HOPE PHYSICAL THERAPY-PARKING LOT

CONSTRUCTION DOCUMENTS

PPR-23-024

V1_Site Development Plan 2.pdf Markup Summary

DETAIL GRADING

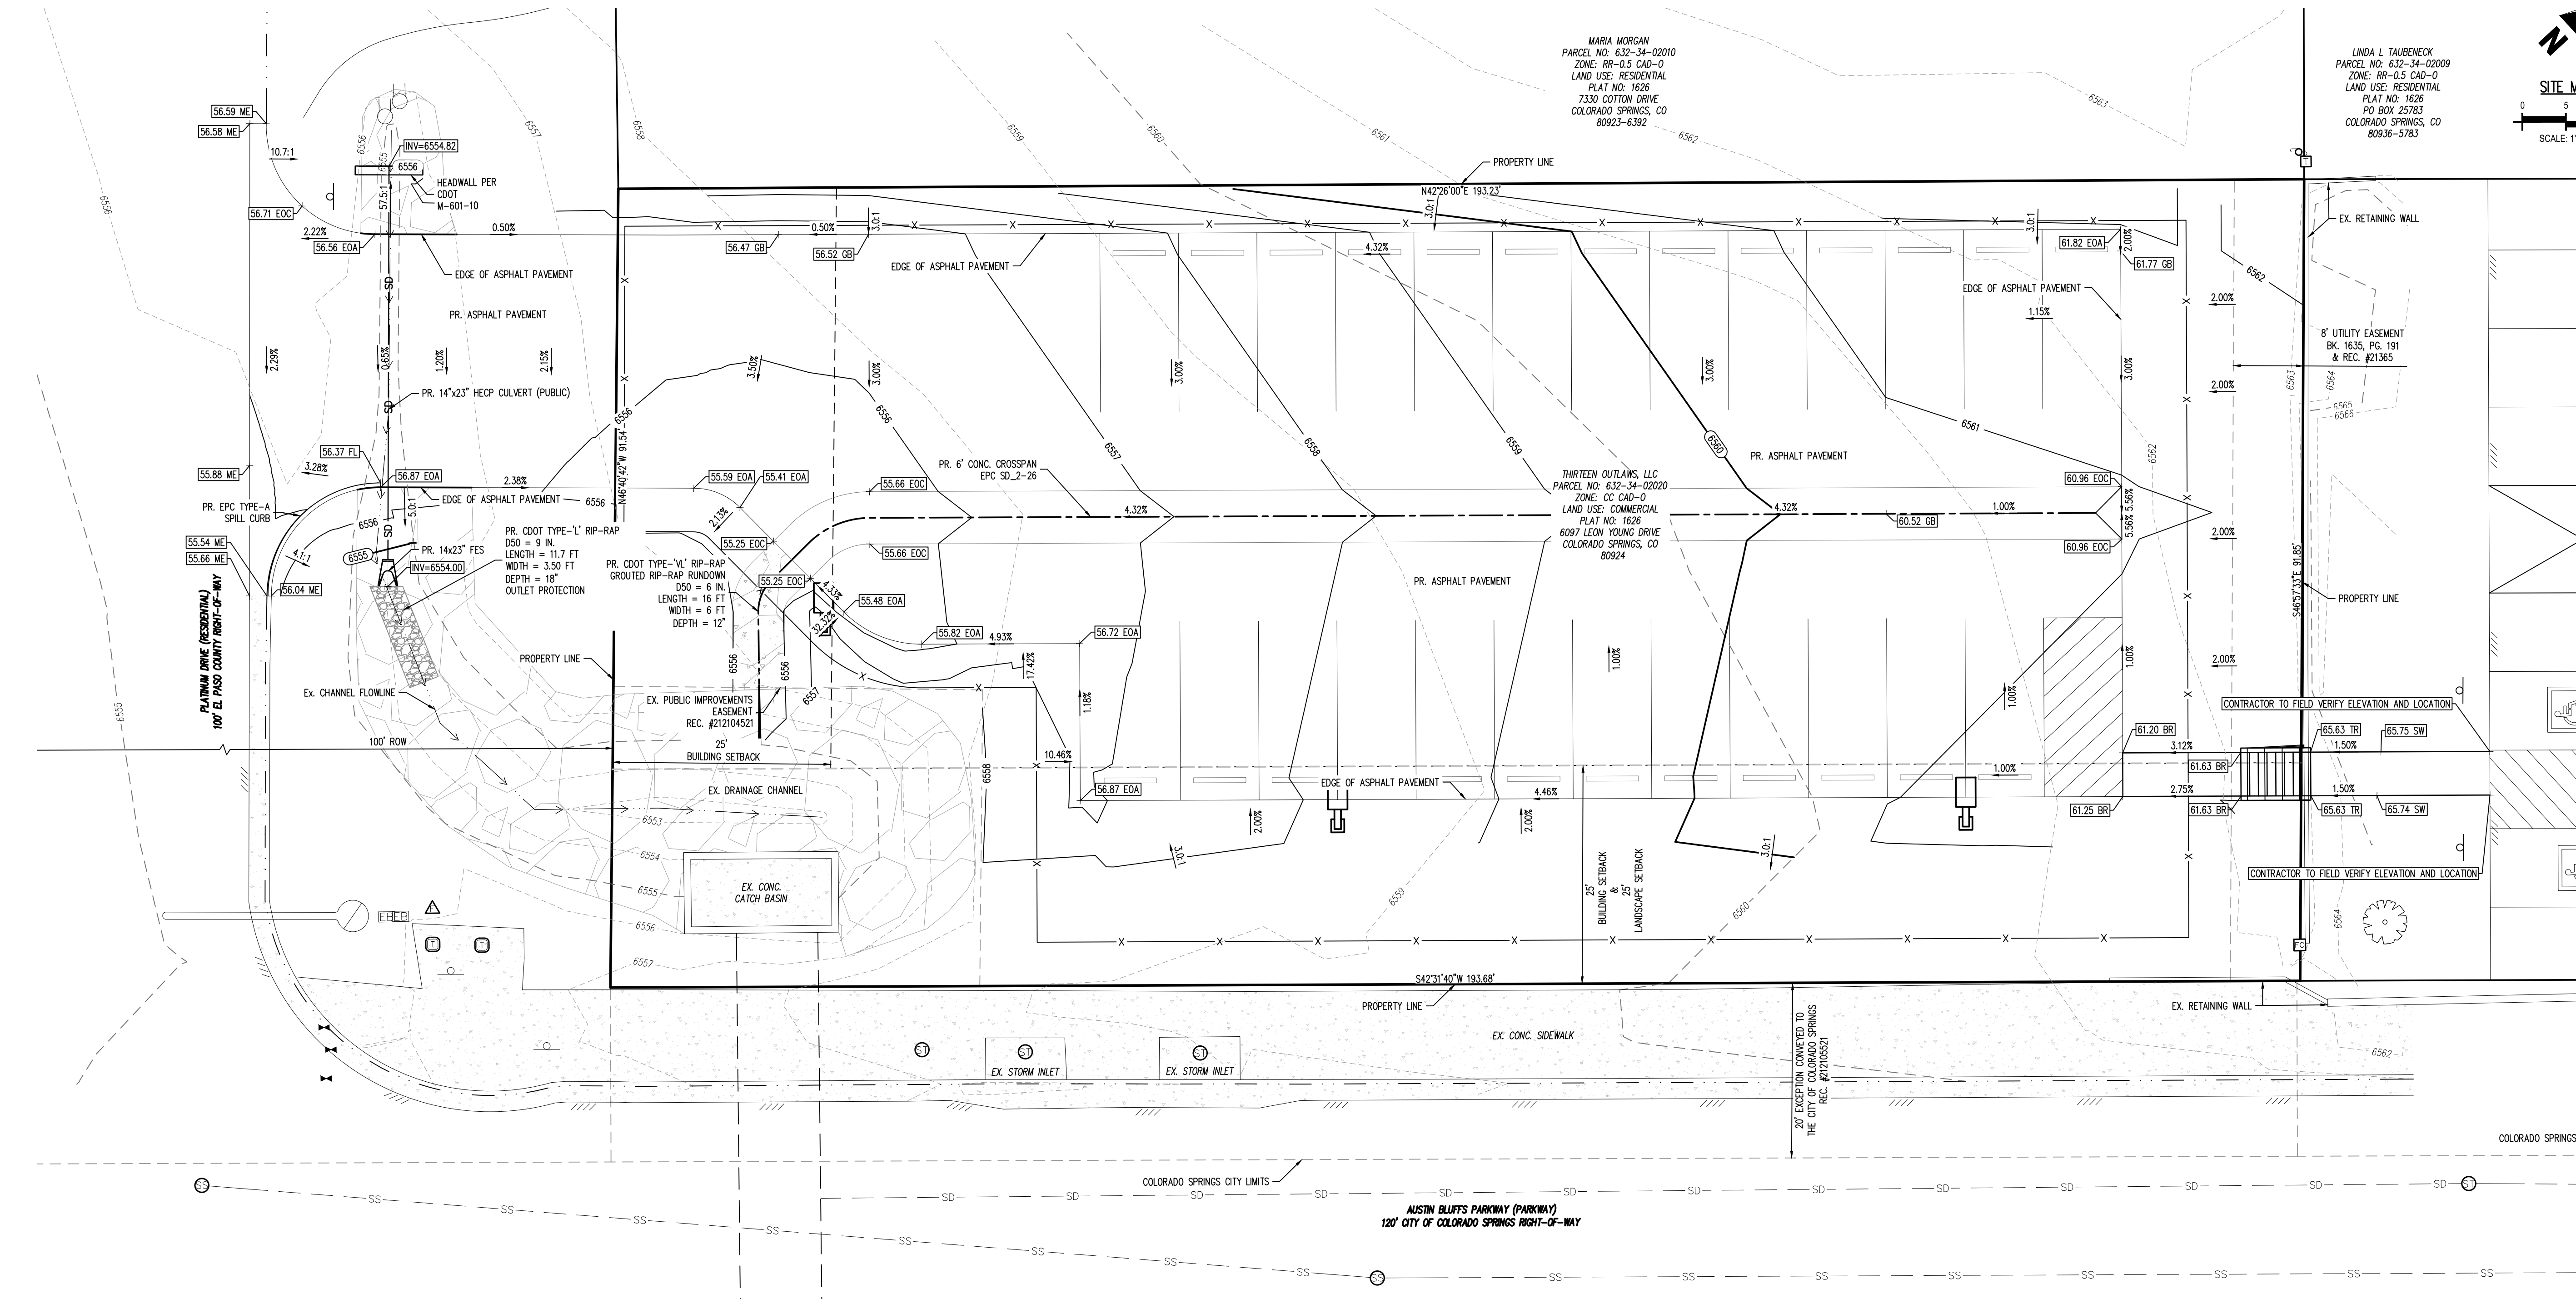
Show channel flowline

Label headwall & provide detail

Provide dimensions & detail for outlet protection

Provide invert elevations for culvert

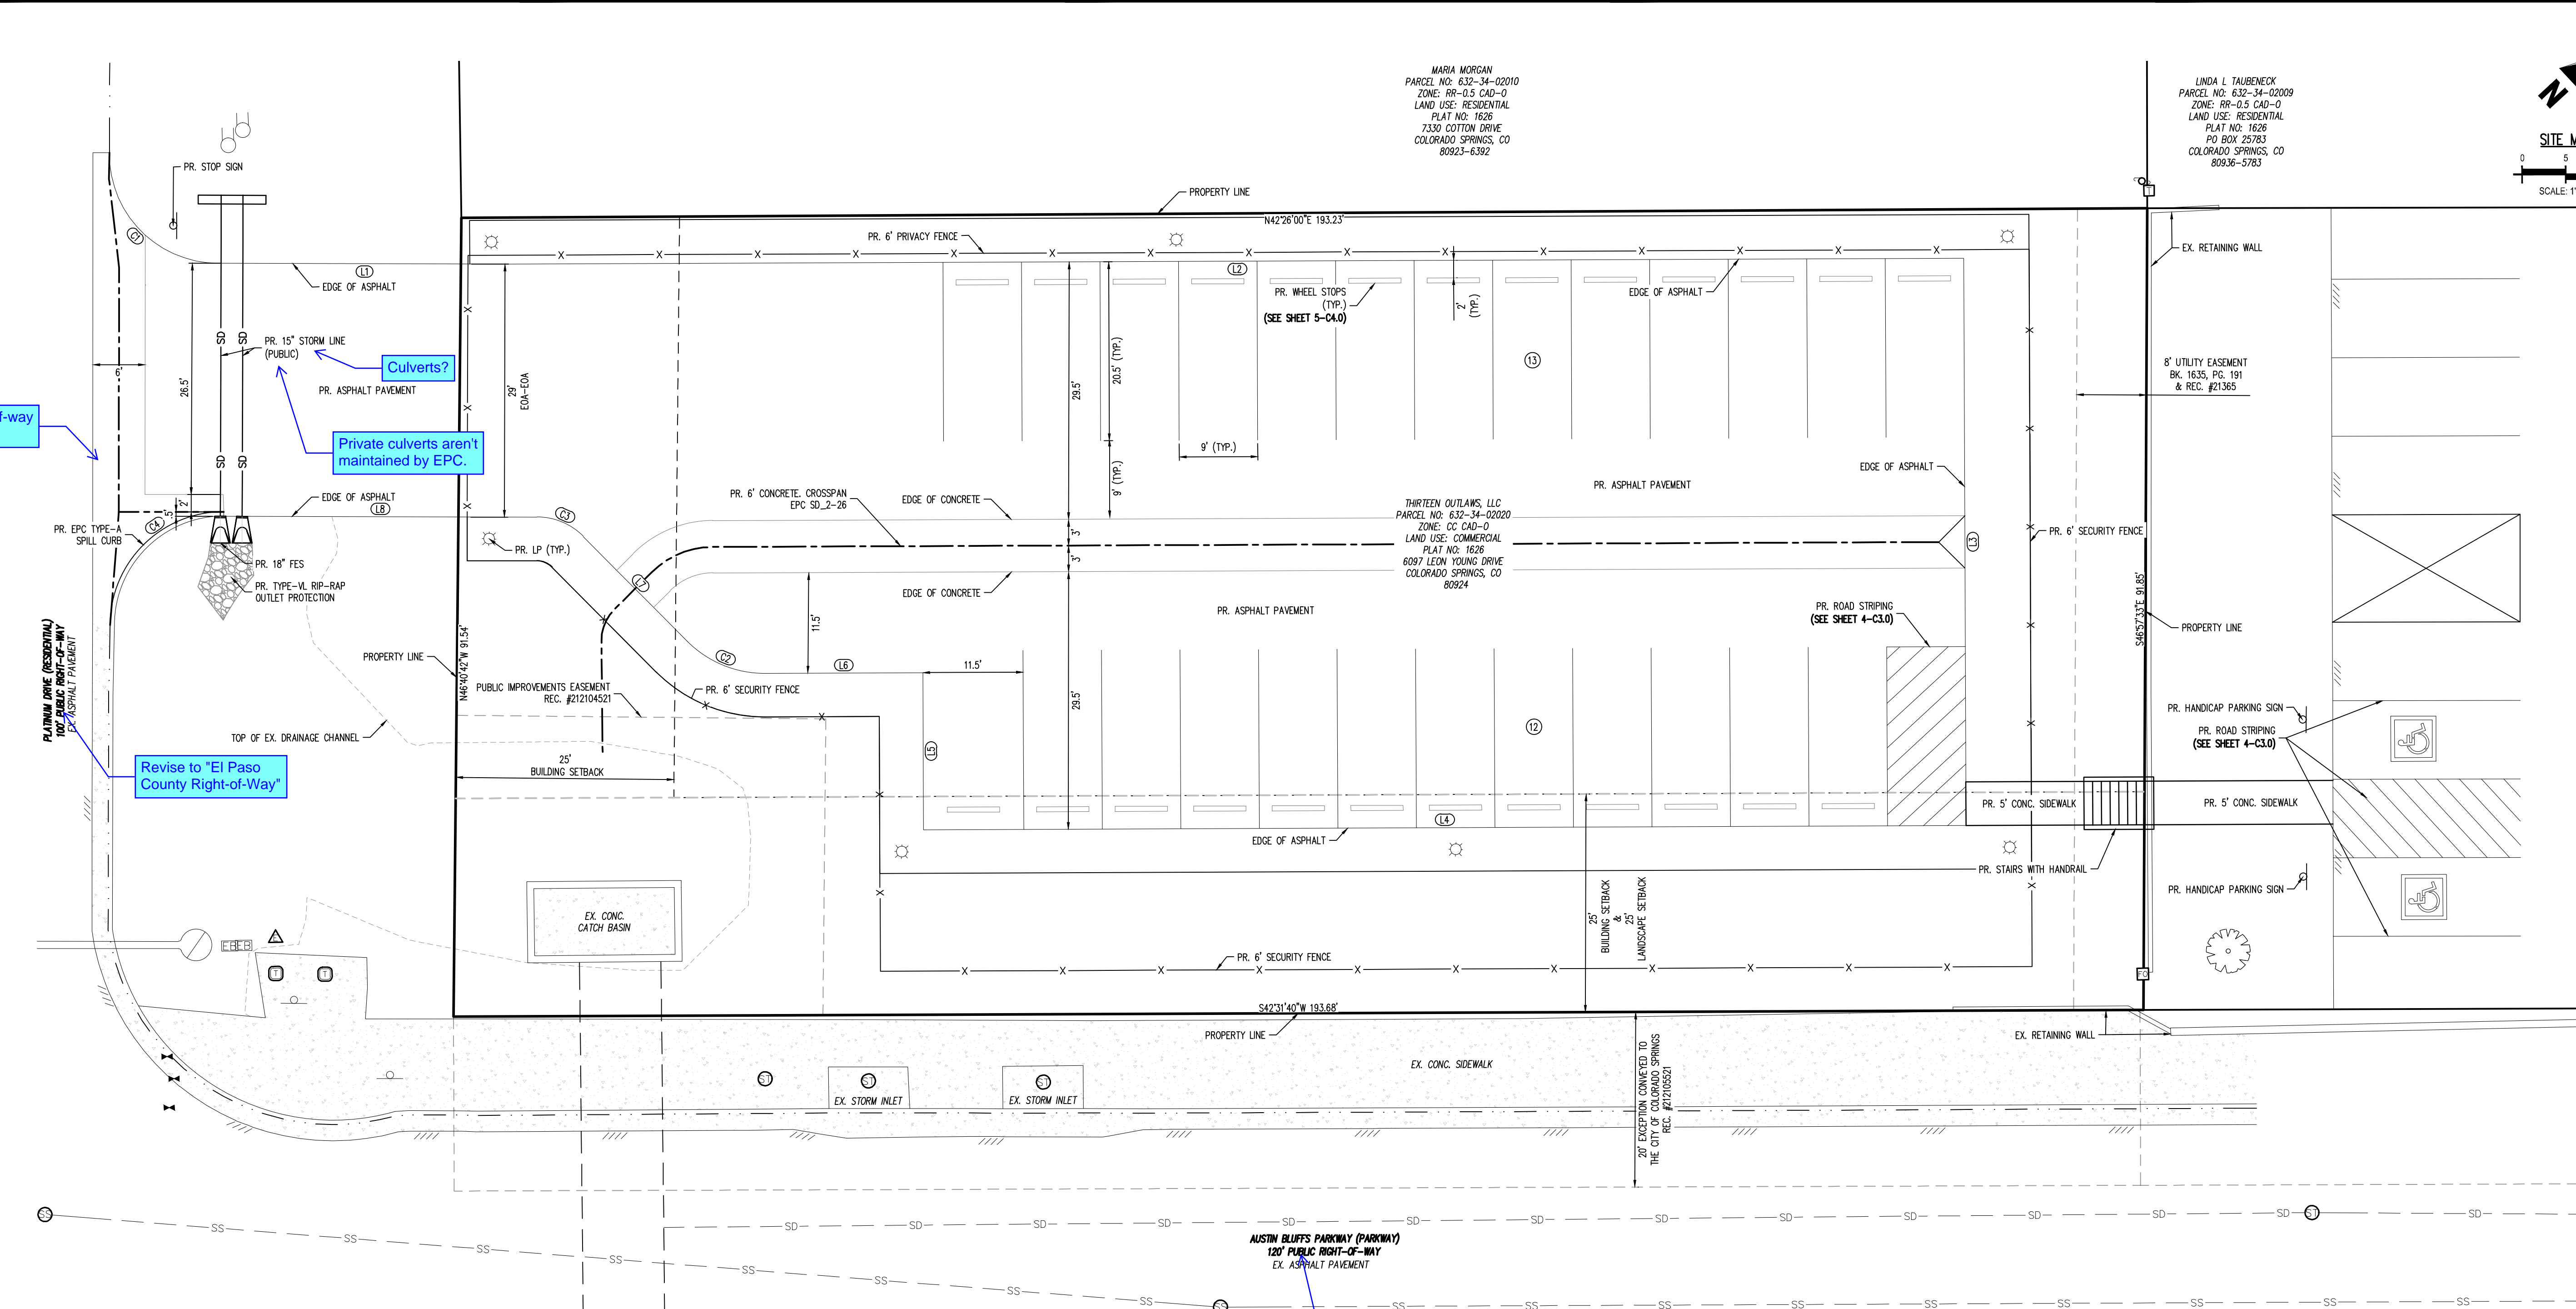
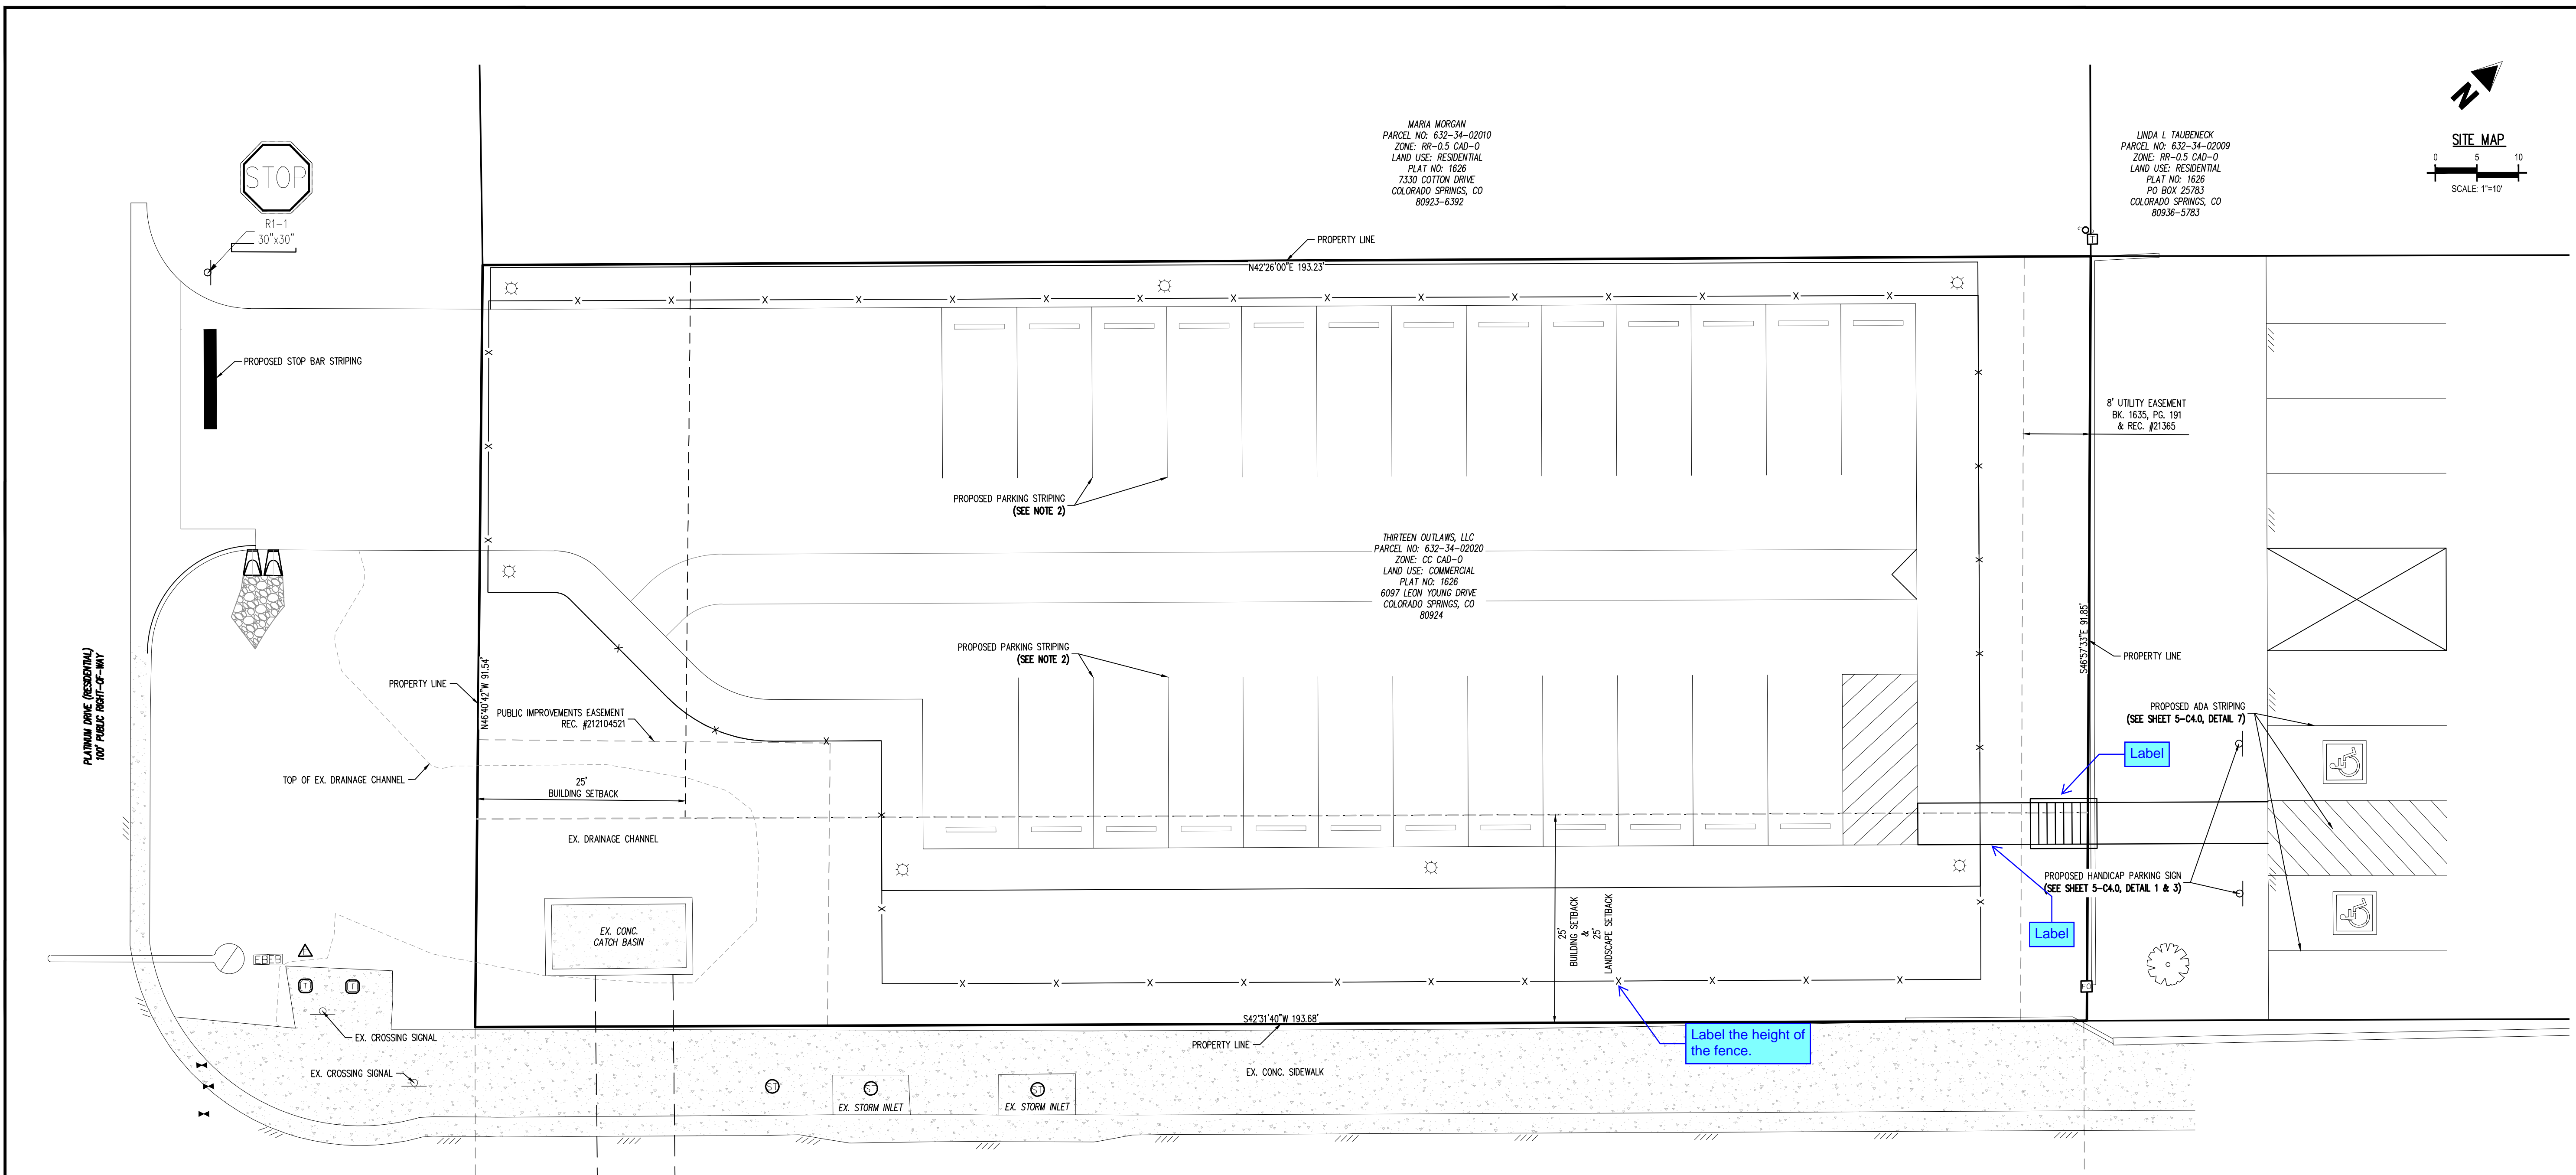
Label right-of-way line

Revise to "El Paso County Right-of-Way"

Revise to "City of Colorado Springs Right-of-Way"

Culverts?

Private culverts aren't maintained by EPC.

Label tie-in & provide northing/easting

Label tie-in & provide northing/easting

Label start & end of pan flowline. Include northing/eastings

Culvert & FES size do not match. Please revise

Label cross pan

Label headwall

What is this line? Please label

Label

Label existing items
